13 October 2022

Natasha Homsey
Environmental Assessment Officer
Department of Planning and Environment

Liverpool Range Modification 1 (SSD-6696 MOD1)
Muswellbrook Shire Council – MOD1 Objection

Liverpool Range Wind Farm
Indicative Over-size/over-mass (OSOM) Haulage Route - Port of Newcastle to Project Site

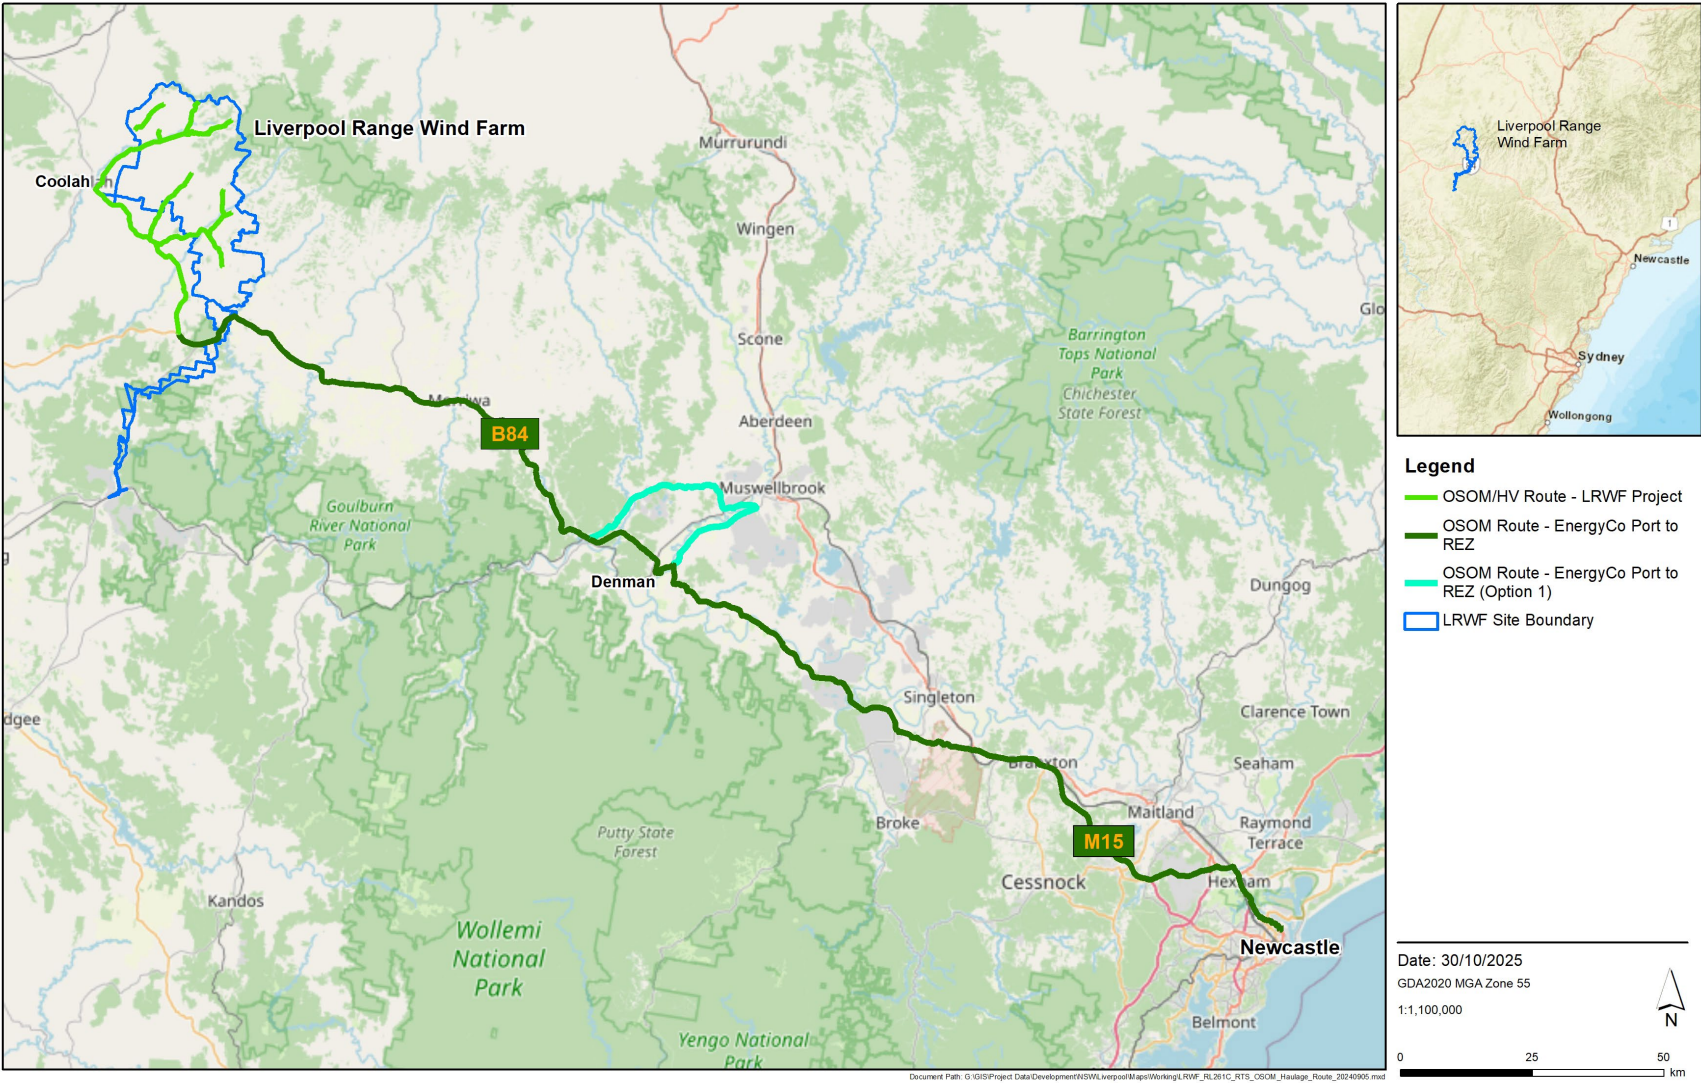
- Transportation of 90m wind turbine blades (and loads >5.2m height), originating at the Port of Newcastle, via the following Council local roads (**Figure 1**):
 - Bengalla Link Road;
 - Wybong Road; and
 - Edderton Road
- Proposed upgrades to the abovementioned roads to facilitate the movement of 660 Over Size Over Mass (OSOM) vehicles required to transport the blades; and
- Removal of up to 0.1ha of native vegetation from Wybong Road.

5. Use of Council owned local roads (as opposed to State roads) is a constraint caused by the Denman Road bridge crossing of the Hunter River (height limit restricted). Note that the proposed 100-110m blade for Barney's Reef and Spicer's Creek may also be constrained by the newly constructed Mangoola overpass on Wybong Road.

8. Road conditions are broadly described as a country road standard with narrow lane widths, unformed shoulders, poor pavement depths, aged sealed surfaces, drainage structures that will not support repeated heavy loads/turning movements; and road gradients unsuitable for transport of long loads. Some roads have known accident history including fatalities (discussed below) and form part of local bus routes.

Note that Council Officers have recently been restricting OSOM movements on Wybong due to lack of passing opportunities caused by saturated table drains.

The Proponent is proposing to remove 0.1ha of native vegetation from Wybong Road. There are extensive remnant patches of vegetation adjacent to Wybong Road that serve as a link between the Manobalai Nature Reserve and Wollemi National Park. These patches provide scenic amenity values for road users and Council officers would prefer vegetation remain in-situ.

- A Detailed Route Analysis considering road furniture, geometry, load limits, safe sight distance, private property and Council road impacts, turning circles by a suitably experienced and practicing consultant is to be provided to Council.
- Written consent of the impacted private property owners along the route, including any written correspondence between parties and contact information.
- A joint dilapidation survey with Council.
- Structural assessment of all drainage structures along the proposed route that has not had a recent condition assessment with proposed design loads exceeding existing load compliant traffic along the proposed road route.

A Transport Management Plan submitted to Council for the route by a suitably experienced and practicing consultant showing:
